From: Andrew Wood <Andrew.Wood@arun.gov.uk>
Sent: 23 February 2021 15:10
To: Planning.Responses <Planning.Responses@arun.gov.uk>
Subject: FW: Arundel Road, Walberton: Planning Consent WA/63/19/PI

Subject: RE: Arundel Road, Walberton: Planning Consent WA/63/19/PI

Andrew -- Based upon the current drawings/calculations/maintenance manual, I can now confirm that the proposals are acceptable. This relates to conditions 6 and 7. It would be a good idea to upload all the correspondence on this matter to the planning portal.

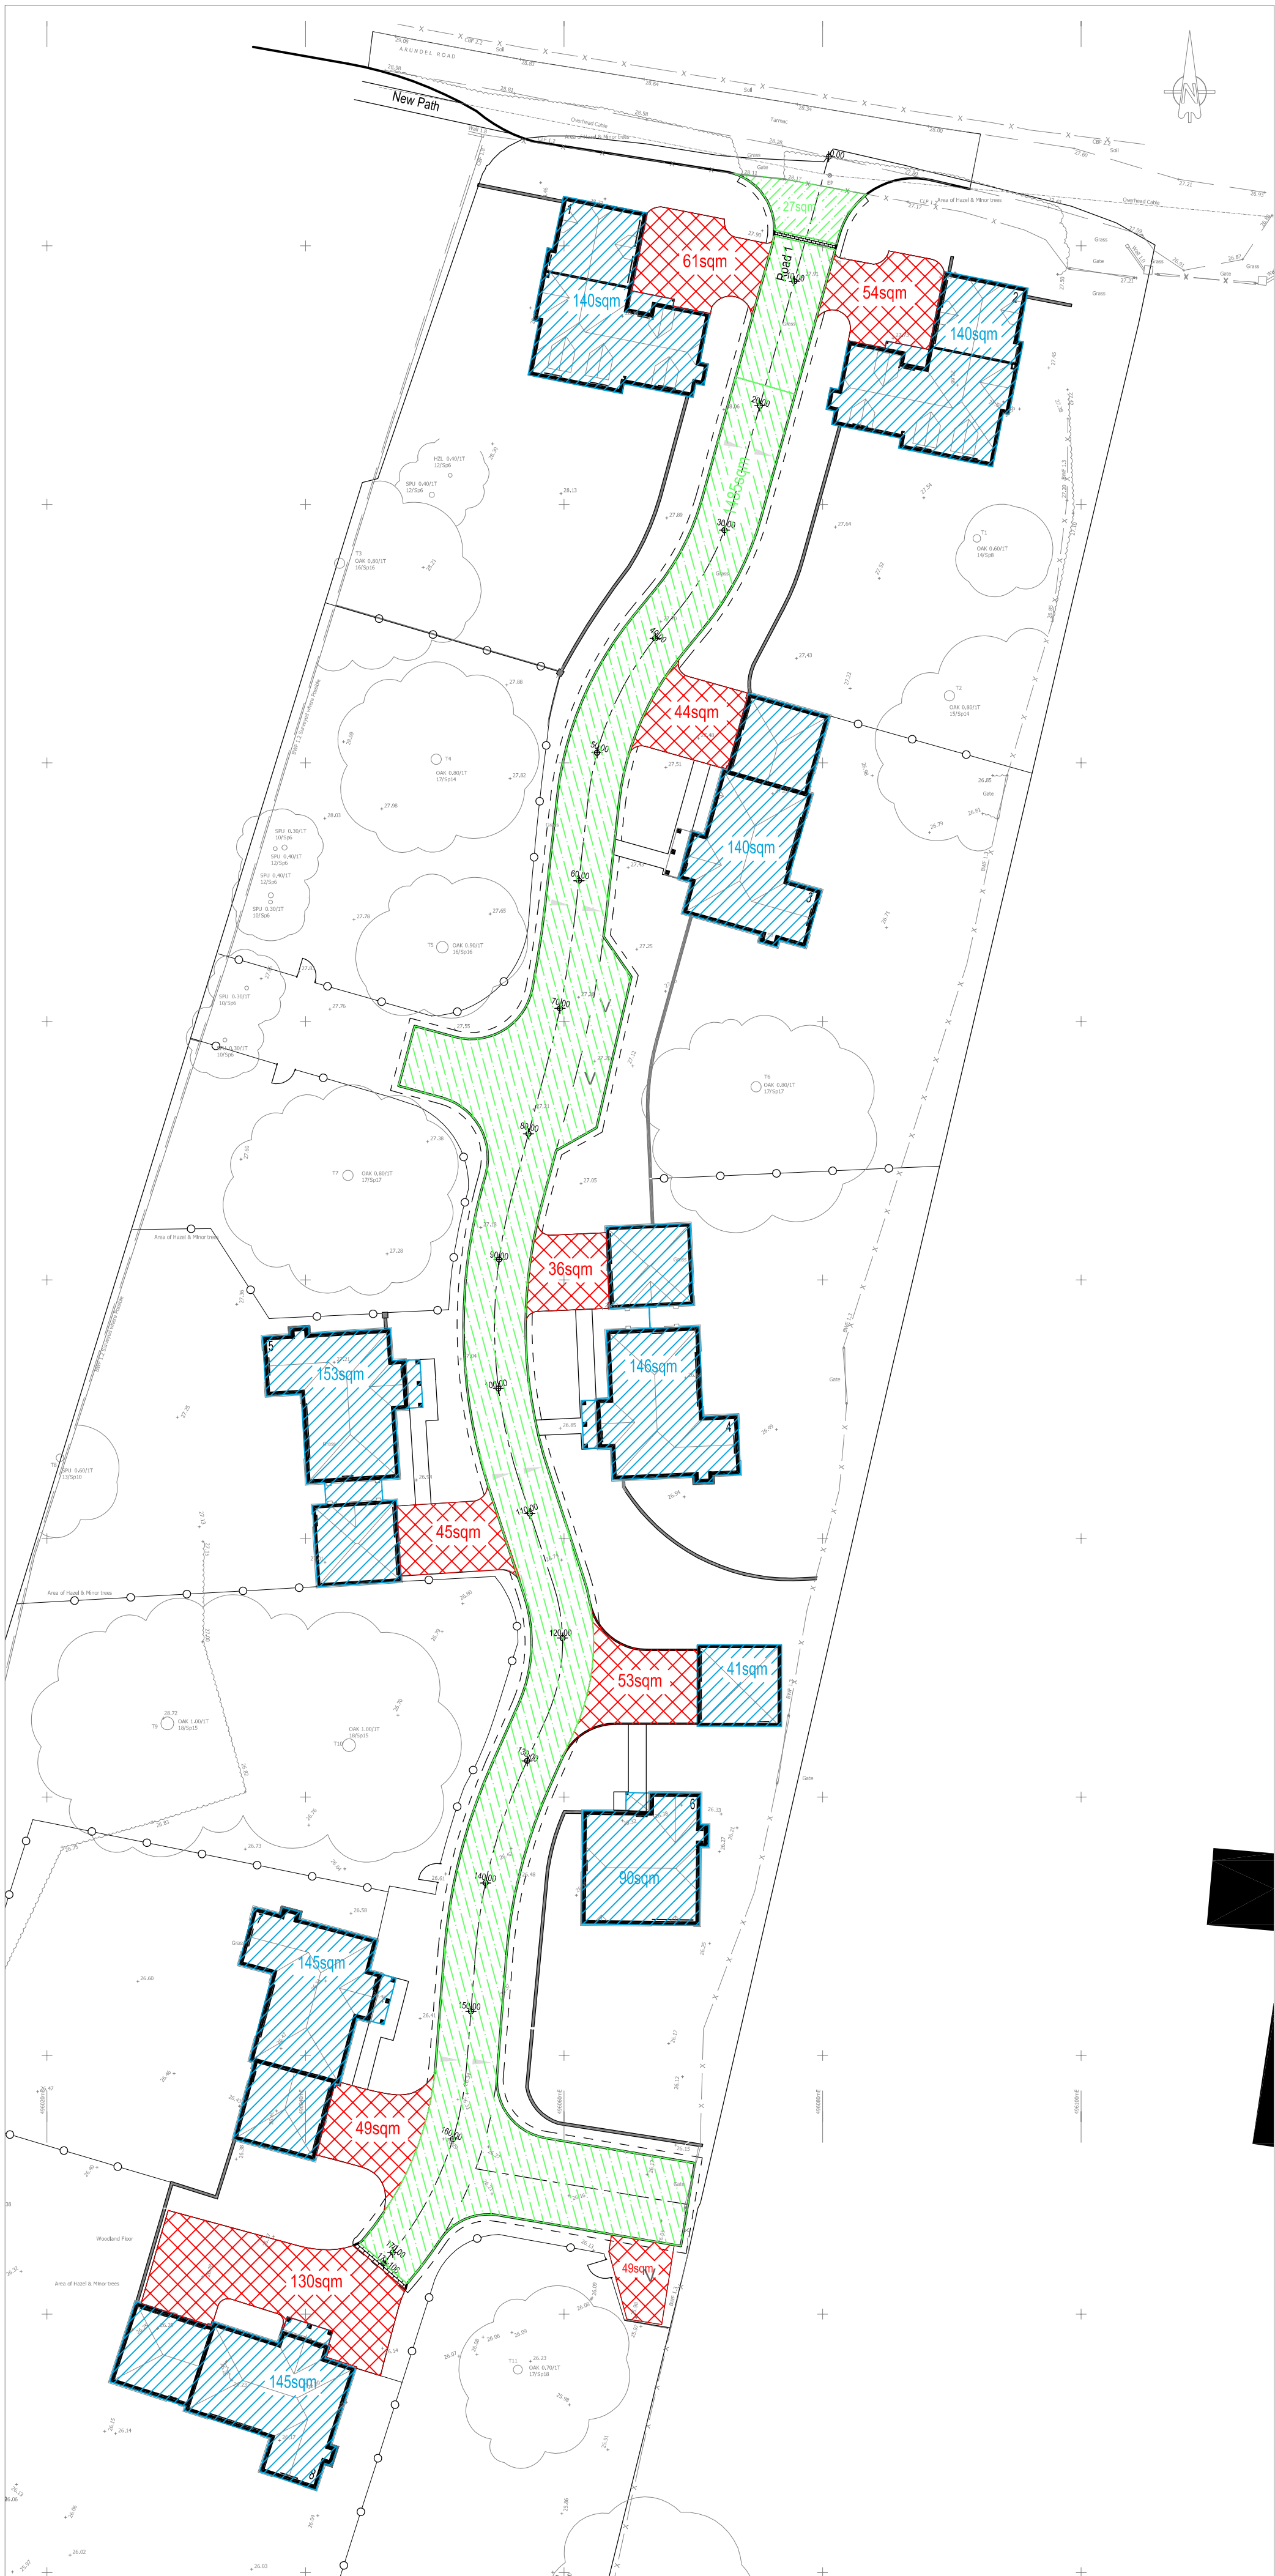
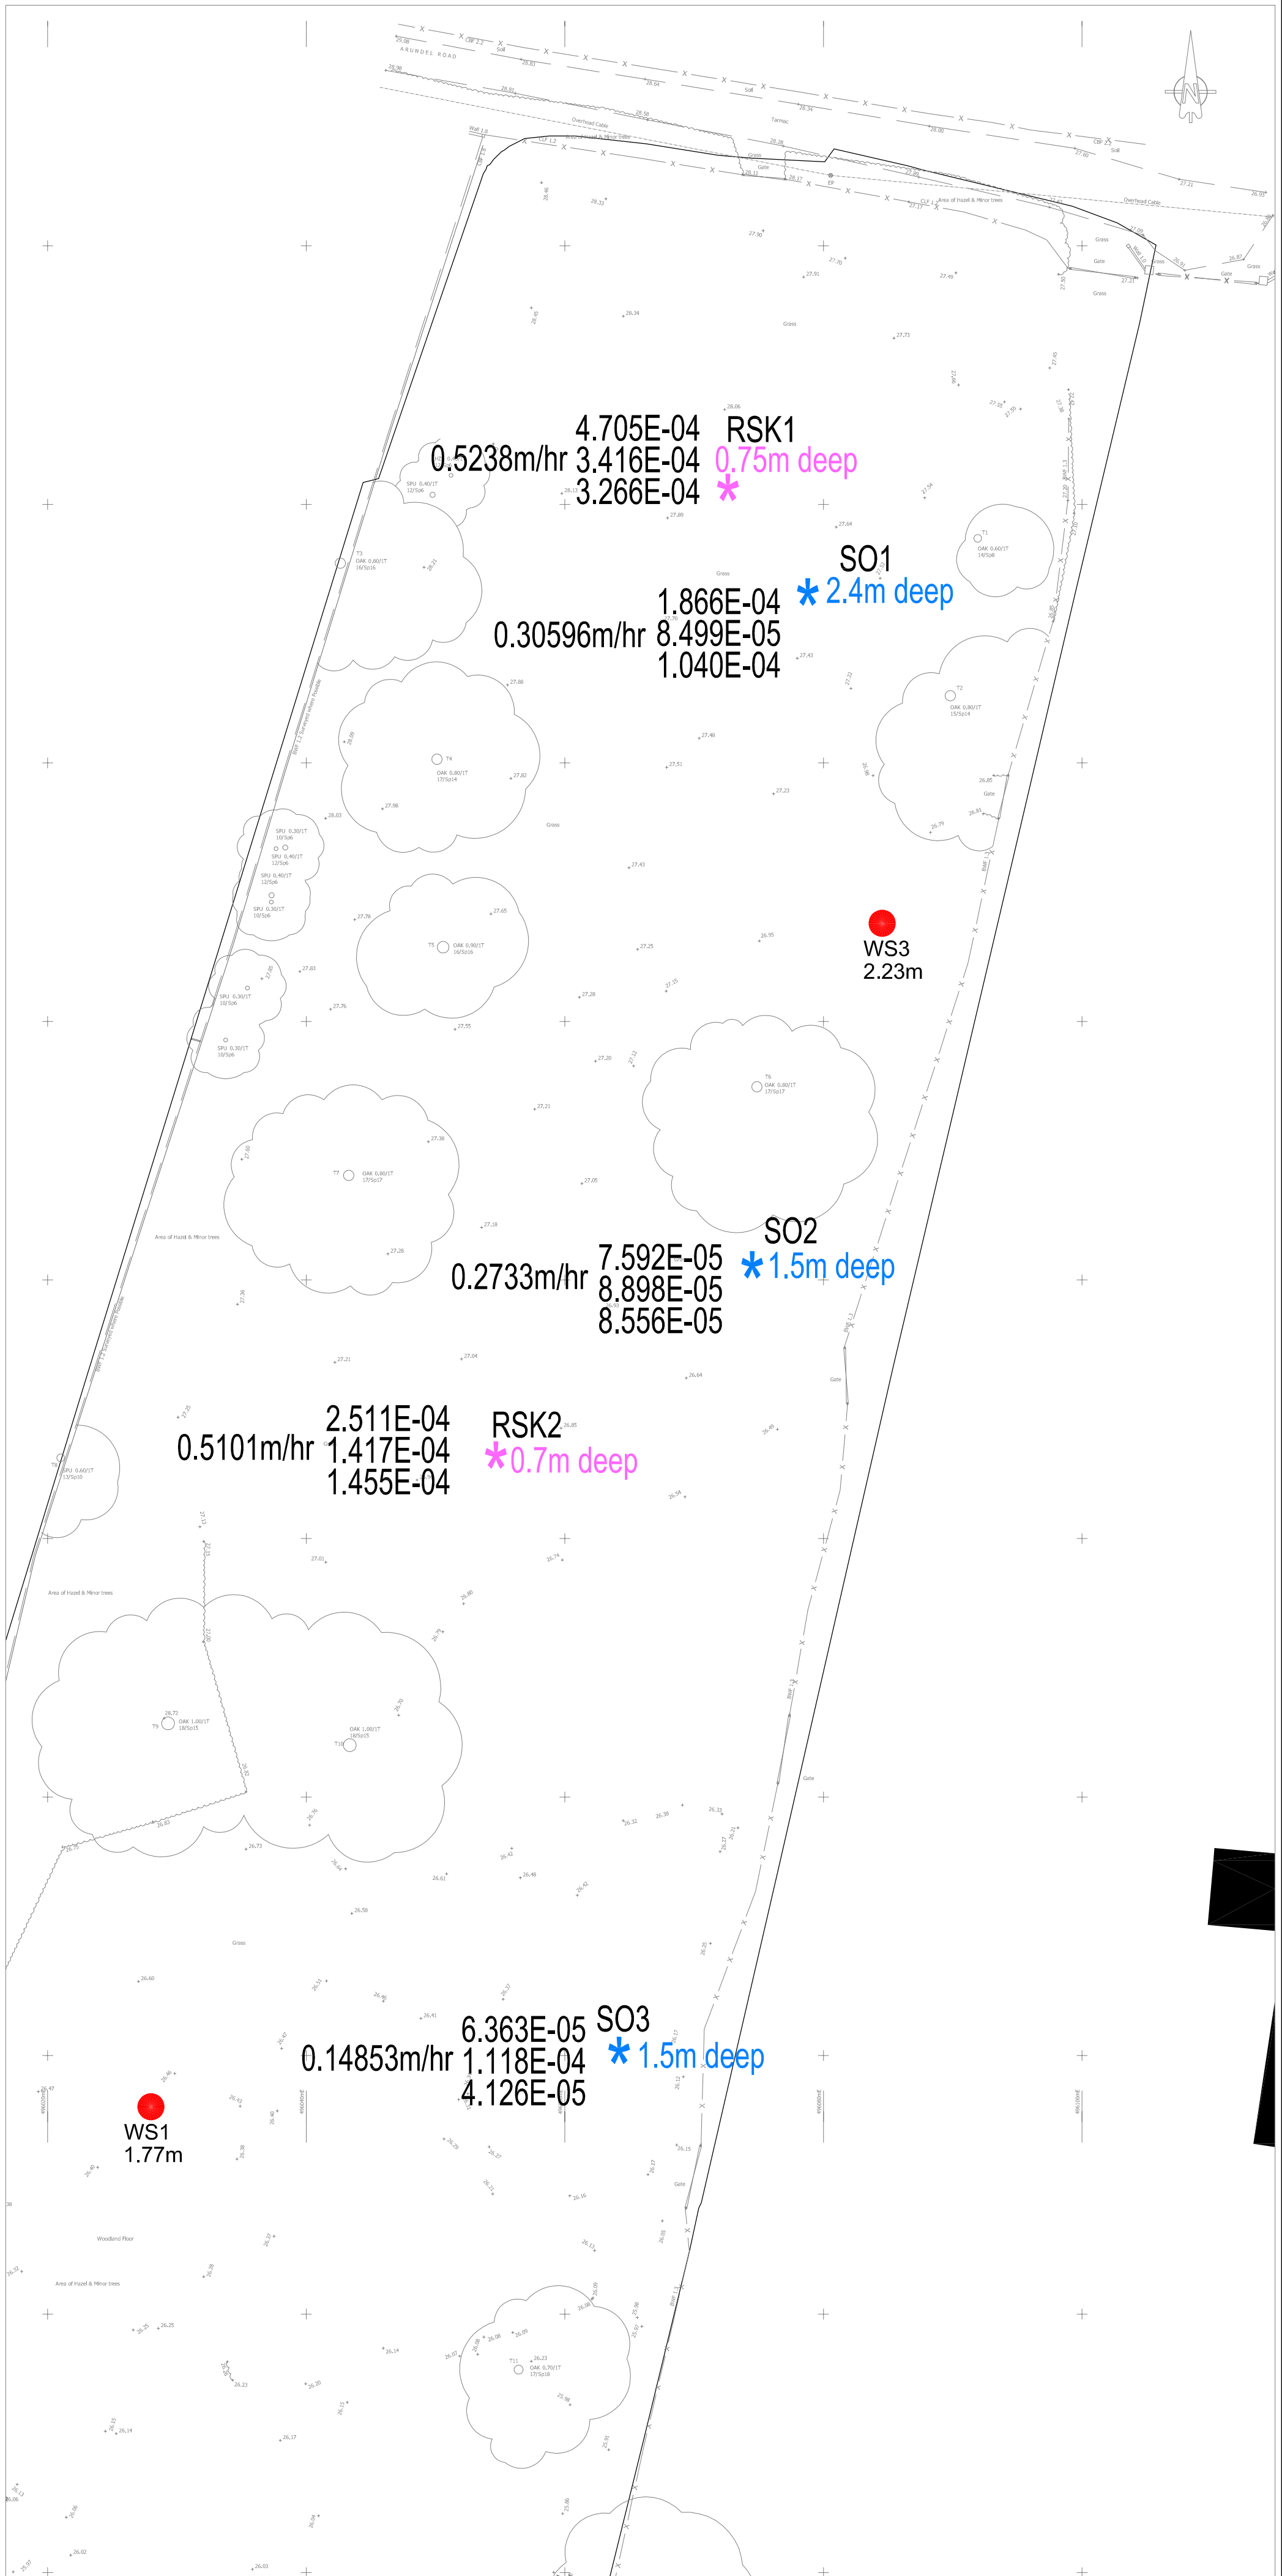
1. Add pipe gradients to plan. Added ok
2. Rodding eye schedule on plan – R13 to R17 information incomplete. Added R16 & R17 IL should be 25.950?
3. The infiltration testing was carried out in March 2019. We would have expected this to be carried out in perhaps Jan/Feb and the tests undertaken at the proposed depth of structures. However, since you have applied reasonable safety factors in the calculations/construction and infiltration potential across the site is good, we will accept the testing on this occasion. Noted --
4. The infiltration testing in S01 was carried out too deep (ie. below the level of recorded peak groundwater levels). Therefore this rate (zone 1) is not usable and the calculations need to be adjusted accordingly. }

disagree with this. The highest recorded groundwater level in WS3 was 2.23m BGL which is 24.72m AOD. A ground level of 26.71 is indicated at WS3 on drg 500-01 Rev A (Drained Areas portion). Therefore, groundwater level would have been recorded at 24.48m AOD. Having said that I must have misread or interpolated something incorrectly, so please ignore comment no.4. The test S01 was taken at a level of 25.13m AOD. The soakaways sited in Zone 1 have base levels of So1-25.50, So2-24.90, So3-25.0 & So9-26.45. I therefore feel that both the testing and the soakaway base levels are above the highest recorded groundwater levels and the calculations are appropriate. ok

5. Infiltration zone table on layout plan – zone 3 should be 4.126×10^{-5} as opposed to 10^{-6} – shown correctly in calculations. Noted, a typing error and table has been amended ok

6. Some the house soakaways are too deep in terms of depth between ground level and base level ie. they must not be deeper than peak recorded groundwater levels in that area. Interpreting peak gwl's between boreholes is acceptable, however, soakaways S01 and S02 should use readings from borehole WS3. Ideally more boreholes should have been installed due to the slope of the land. As above, the level of groundwater at WS3 is 24.27m (24.72/24.48) AOD and is approx. 30m from So1 & So2. The ground level difference between these soakaways and WS3 is between 1.18m and 0.69m I do not think it is unreasonable to assume that the ground water level at the soakaways is no greater than 0.18m above this level (this is the distance between the base level of the deepest soakaway So2 and the highest water level in WS3. As a comparison the water level recorded at WS1 was 24.63m AOD with a ground level difference of 0.55m over a distance of 105m. I agree with your comment, another borehole, WS2, was installed between WS1 & WS3 but unfortunately it was damaged and no readings are available. ok – see item 4 above.

7. Specify oblique 45 degree junctions where pipes do not connect to manholes. Note 19 added specifying 45 degree junction ok
8. Add finished surface levels to the plan for driveway permeable paving areas. Levels added ok

2. Rodding eye schedule on plan – R13 to R17 information incomplete. Added R16 & R17 IL should be 25.950? I have amended these (typing error!) ok
